DELEGATED HOUSEHOLDER DECISION

Item No. Report of the Head of Planning & Enforcement Services**Address** 94 RALEIGH AVENUE HAYES**Development:** Part two storey, part single storey rear extension, involving alterations to front and side elevations and demolition of existing rear element**LBH Ref Nos:** 67971/APP/2011/1894**Drawing Nos:** KGS/RAL/403P1A/1
KGS/RAL/403P1A/2
Location Plan**Date Plans Received:** 02/08/2011**Date(s) of Amendment(s):** 03/08/2011**Date Application Valid:** 08/08/2011**1. CONSIDERATIONS****1.1 Site and Locality**

Drawing Title : ELEVATIONS & SECTION TWO STOREY REAR EXTENSION 94 RALEIGH AVENUE HAYES UB4 0EF
Drawing No: KGS/RAL/403P1A/2

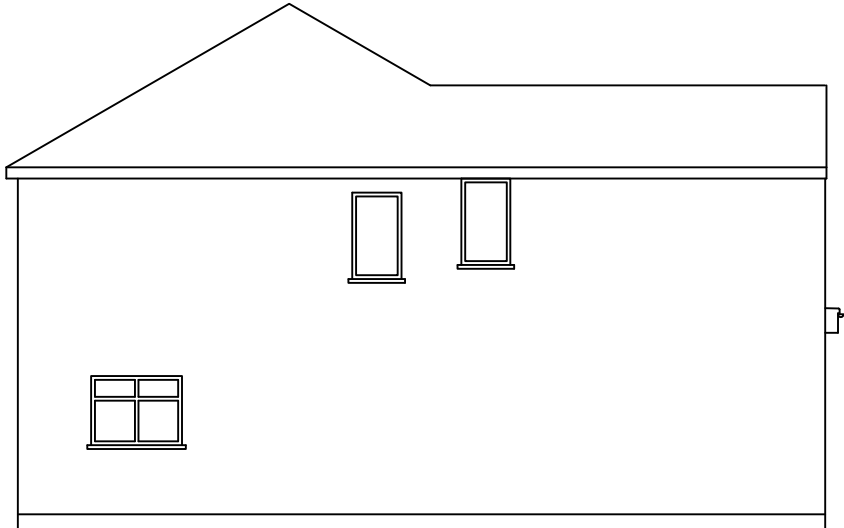
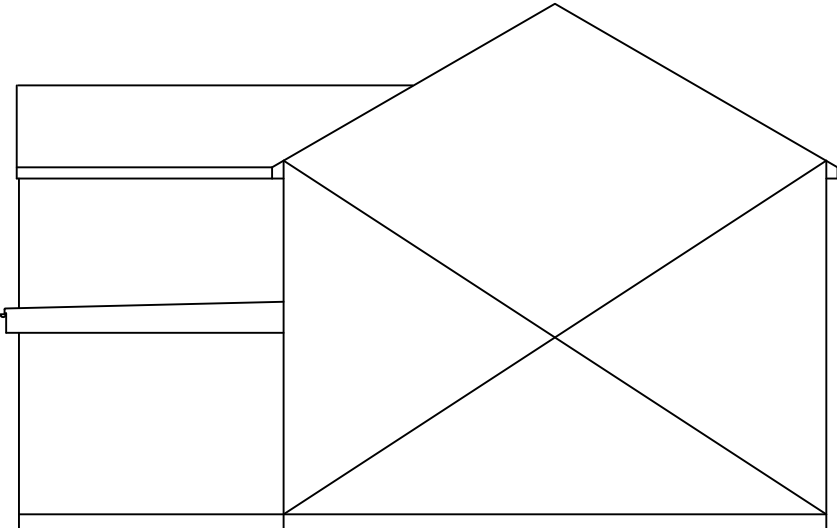
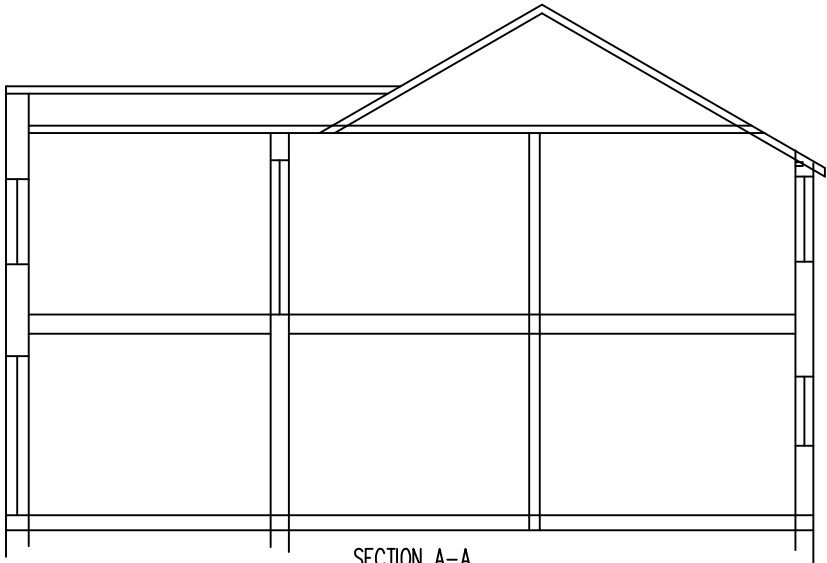
The proposal is for an extension of 3.55m depth and matches the lines of the main roof which is extended back. However, the extension would exceed the 45 degree line taken from the centre of the ground and first floor windows of No. 92 to the south and as such would result in a loss of outlook and daylight for occupiers of that property. The potential for loss of sunlight and thus overshadowing to this property as a result of the extension would though be negligible due to No. 92 being positioned to the south. Nonetheless, UDP Saved Policies BE20 and BE21 seek to prevent new buildings or extensions which fail to safeguard and would result in a loss of the residential amenities of existing houses.

The proposed development by reason of its overall size, bulk, depth and orientation in relation to the adjoining property, No. 92 Raleigh Avenue, would constitute an unneighbourly over-dominant form of development resulting in an unacceptable loss of outlook and daylight. As such, this would be contrary to Policies BE20 and BE21 of the Hillingdon UDP Saved Policies 2007 and to guidance set out in the Hillingdon Design And Access Statement: Residential Extensions (December 2008).
